Steeple_ISH_12 NOV_PT3

FULL TRANSCRIPT (with timecode)

Okay, I'm seeing agreement. Is there anyone online as well who has any comments? If they're happy with working through until 5:00, I'm not seeing any objections, so we'll continue then. Um, so I just want to talk now through the findings of some of the visual effects. Um, and I'm going to focus on the Trend Valley Way. At Fenton Lane is the one example I'm going to to use today.

VIEWPOINT 13A

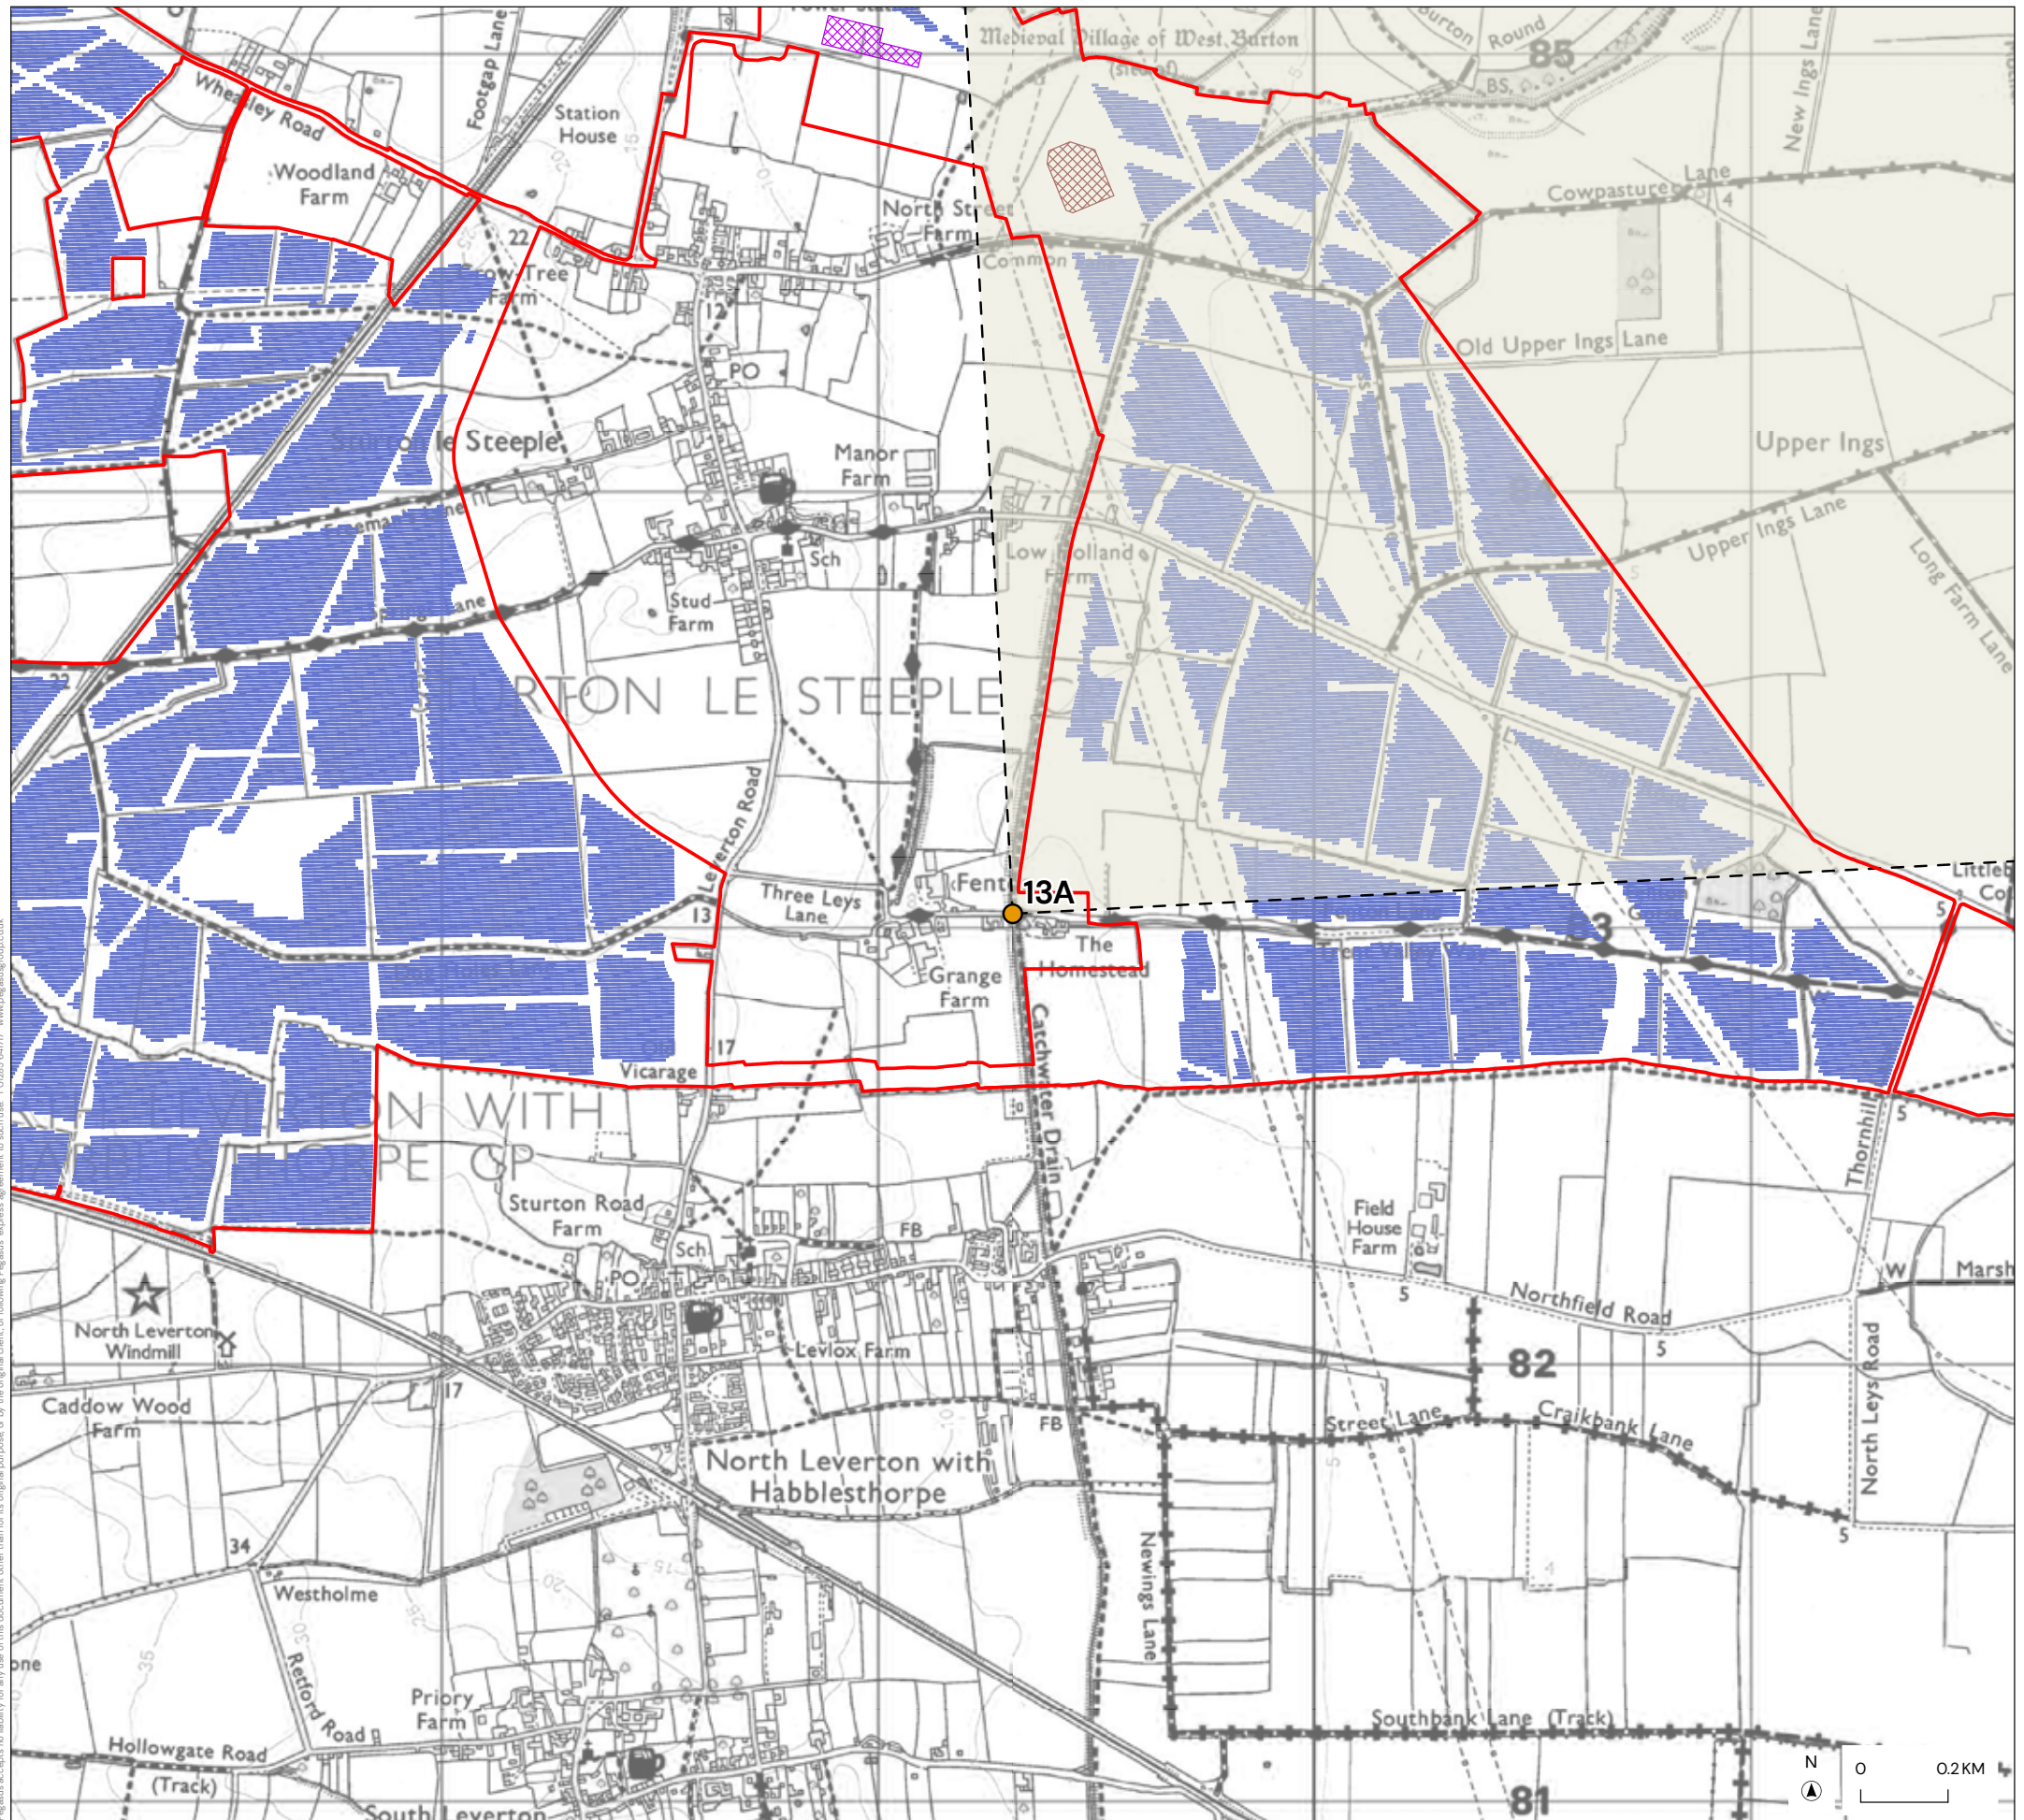
Um, and this is represented by viewpoint 13. So it would be useful if the applicant can um, display one of the photo montages, maybe the winter viewpoint, uh, which is either up 097 or AP 098 and it is 2.13. So once that's been being presented, um, paragraph 6.7.83 in the environmental statement describes the visual effects at viewpoint 13, and it states that the built development will be over 200m away, and there would continue to be a very low magnitude of change and a minor effect at both year one and year 15.

Can the applicant explain why, when this viewpoint is considered at year one? uh, in comparison to what's currently there at the moment. Why you've considered that this is a negligible change in view.

Okay. I appreciate what you say about how you've got to that. And it's the collective. Um, collectively with the distance and the power lines. One thing I wouldn't mind you clarifying, though, is so this viewpoint is, is representing, um, the receptor of the receptors using the Trent Valley Way, the Fenton line in paragraph 6.7. 108 of your environmental statement.

And that includes an assessment again at this viewpoint. And it describes effects for the three layers, lane, Fenton Lane. And it considers the worst case magnitude of impact would be high, resulting in a major moderate significant effect. And at year 15 this reducing to um moderate minor effects in comparison to the effects we've just described in my previous question. Why is there seemingly two different assessment findings for the same viewpoint?

Okay, maybe we could ask for some more clarification for you in writing. If we put that as an action point for you to clarify the, um, assessment findings in, um, between paragraphs 6.7.83 and the environmental statement and those in 6.7 108, because from my reading of it, it appears to be describing different effects at the same viewpoint. But I'd welcome some clarification in writing on that.

So, yeah. Dale Turner for the applicant, landscape and visual matters. Um, as you alluded to, the, uh, the distance 200m is a very important factor when considering our magnitudes of change. Um, and with regards to the limited vertical scale of the panels, that's only three meters in height. A 200 meter distance, uh, can be quite notable in reducing the level of effect. Um, we're also cognizant of the existing nature of the, the baseline landscape into which the change would be introduced. Um, and in this instance, we can see the presence of the overhead pylon lines and the power station.

Um, and there are a consideration as part of our judgment, um, along with the nature of the landscape itself, which is relatively flat and and open in this instance. So it's that combination of the distance

Um, I think you said that it set out that it was very low, um, as opposed to negligible. Um, so in, you know, I would consider negligible to be a degree down from, from very low. Um, but notwithstanding that, yes, if we'd set out it was a very low magnitude of change, then, uh, uh, that would be illustrative of those of those factors. And uh, as I say, the offset is quite noticeable at that point, notwithstanding that when we do the assessment of the route as it continues closer towards the site. We do. Obviously, then begin to identify a greater degree of effect as we come to, immediately adjacent to or passing through the panels themselves.

So to be clear, obviously, that the judgment has changed as we approach the panels. But at this particular instance, with the distance involved in the nature of the view, we did obviously identify that lower magnitude of change.

It certainly wouldn't be our intention to set out two different judgements at the same location. Um, I'm not able to give the detail of that, because I've obviously had a chance to consider those particular paragraphs in detail, but certainly from the same location. We would be expecting the the magnitude of change to be the same. You may get a difference in sensitivity of reception depending on the type of receptor, but certainly with respect to magnitude, uh, the same location should be having the same magnitude identified.

We can set it up with more detail and go back to yes.
